**WEST SUSSEX COUNTY COUNCIL
STRATEGIC PLANNING CONSULTATION**

**SUBJECT: FG/16/15/PL - Cycle store & bin store (amendment to planning application
FG/104/14/PL)**

. Littlehampton Road;Greenyers Field;Ferring. West Sussex

Title: Proposed Site Layout

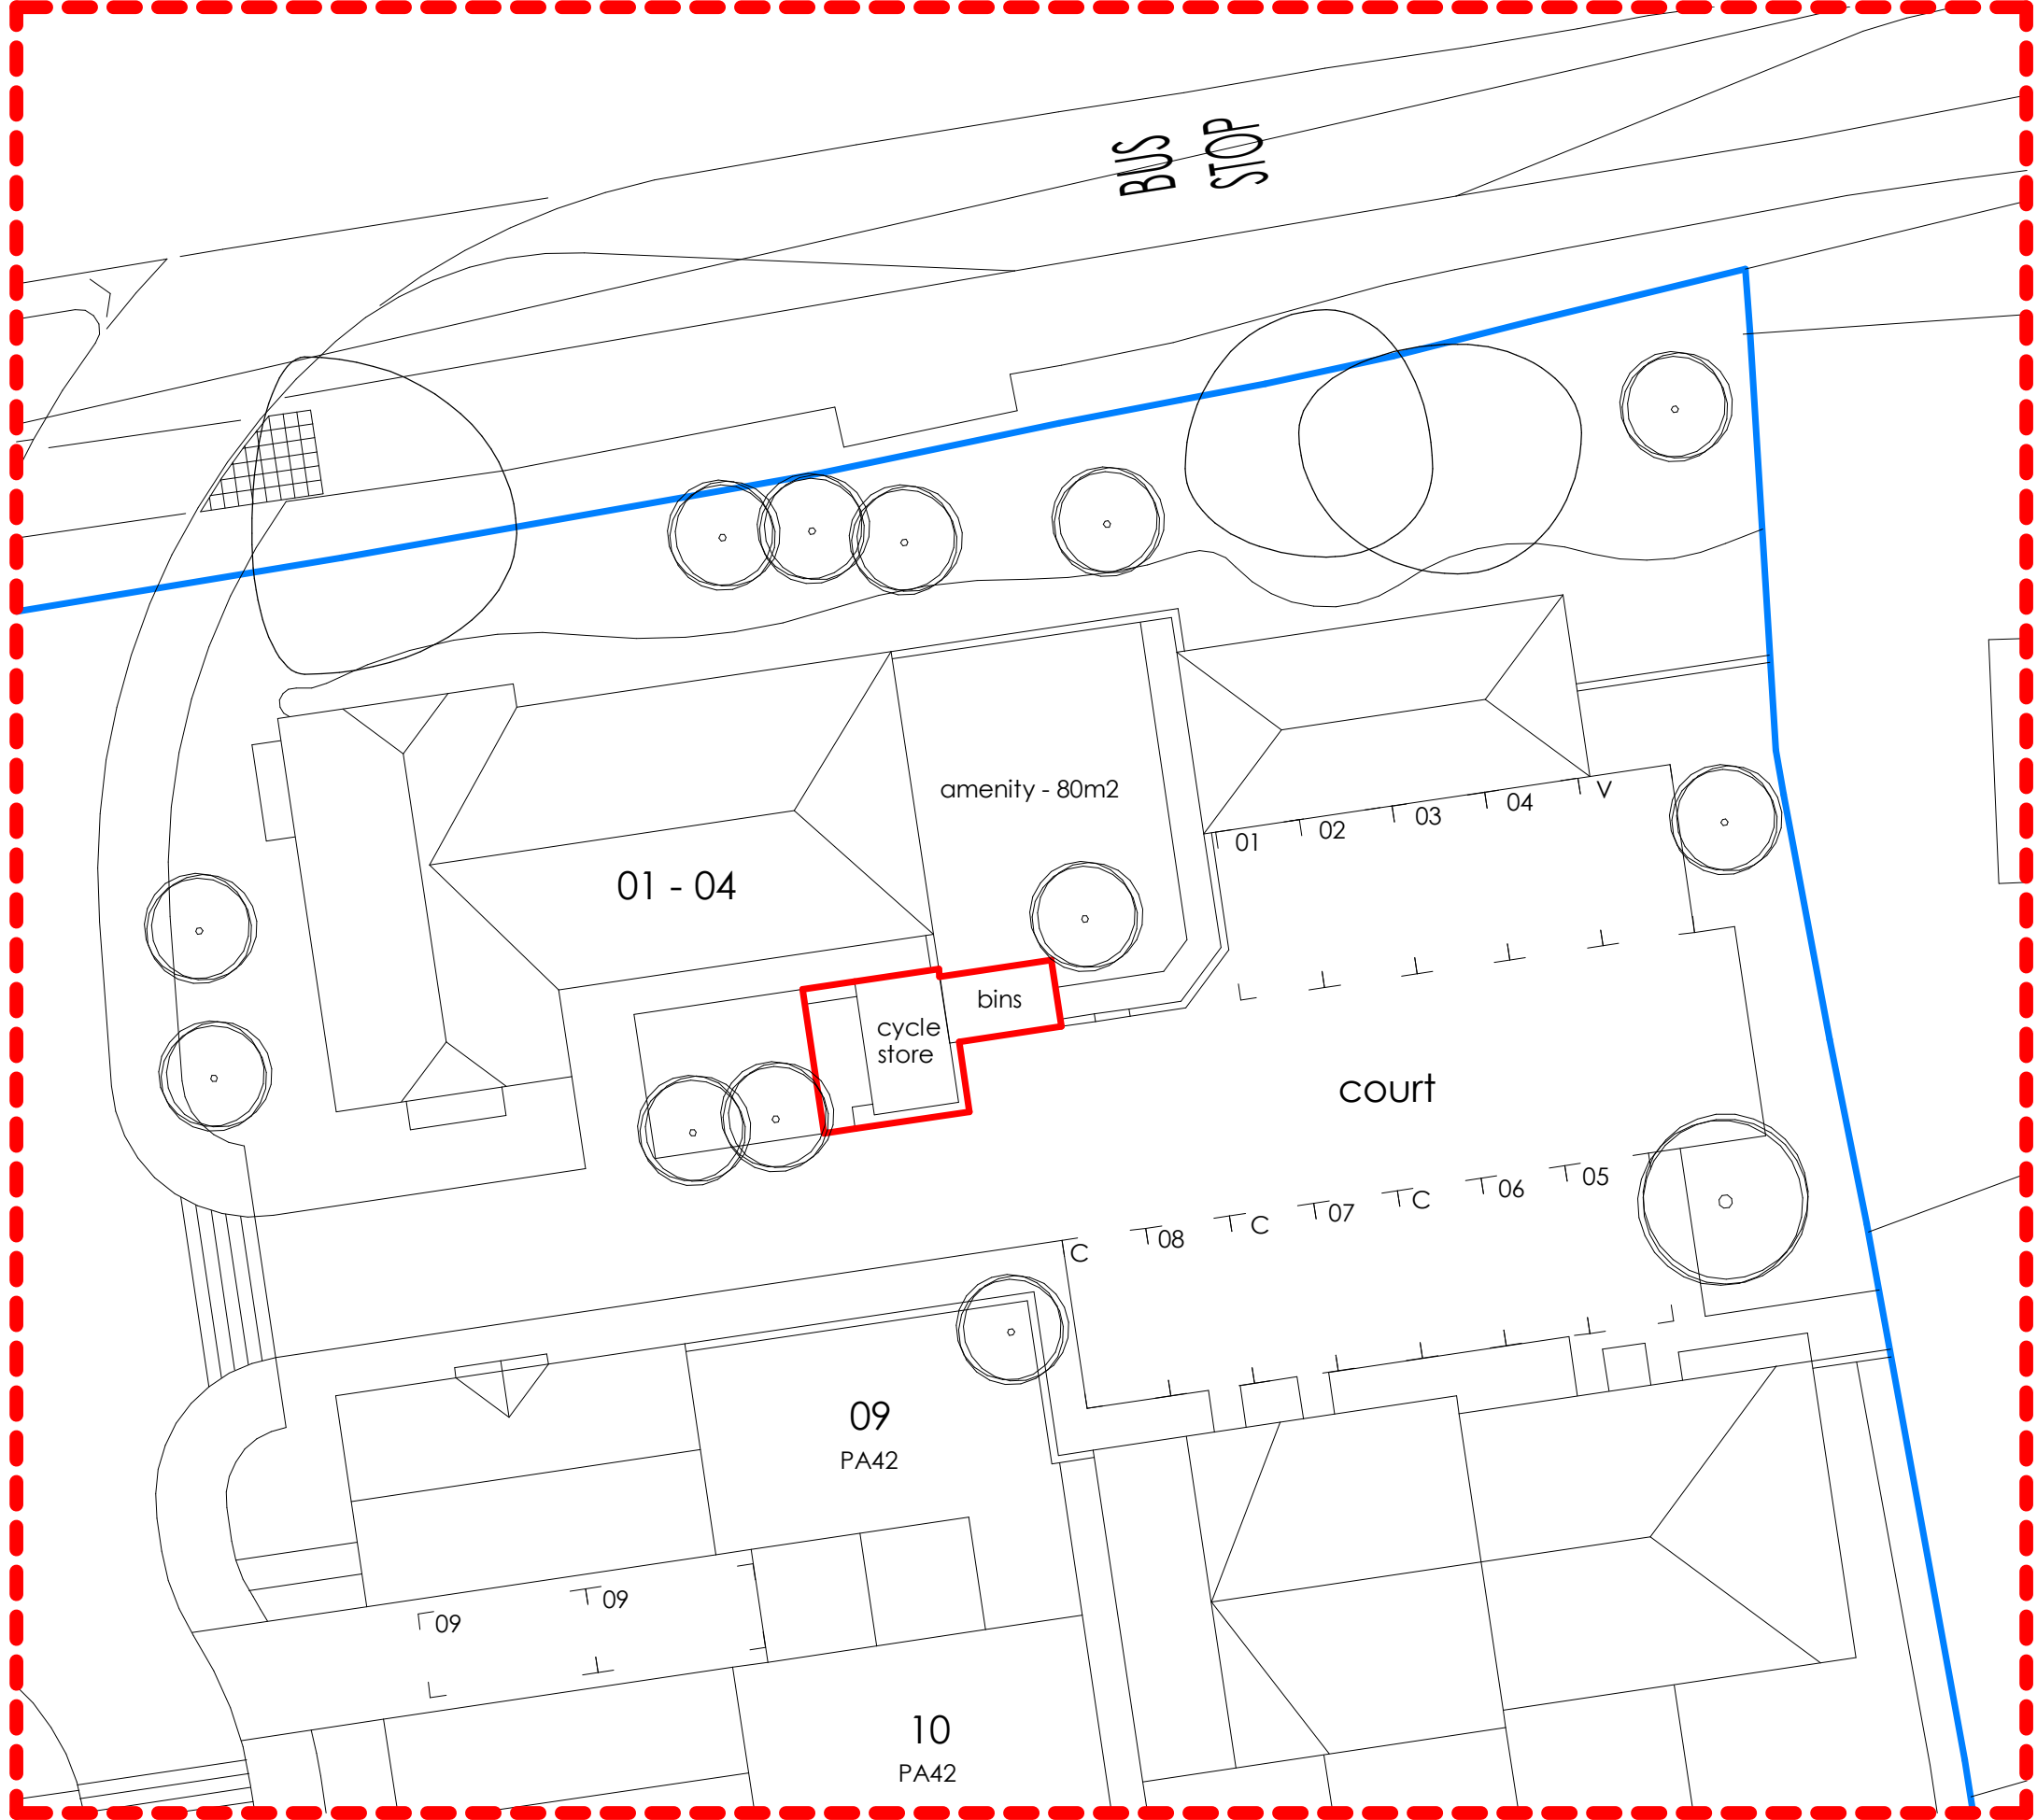
The bin and cycle store has been located within a cul de sac/parking court to the north of the site.

The 'court' parking area adjacent to the bin /cycle store does not include a turning head for large vehicles which would result in some reversing manoeuvres into public highway, however this will occur infrequently and would therefore not raise any serious highway safety concerns.

No highway objection.
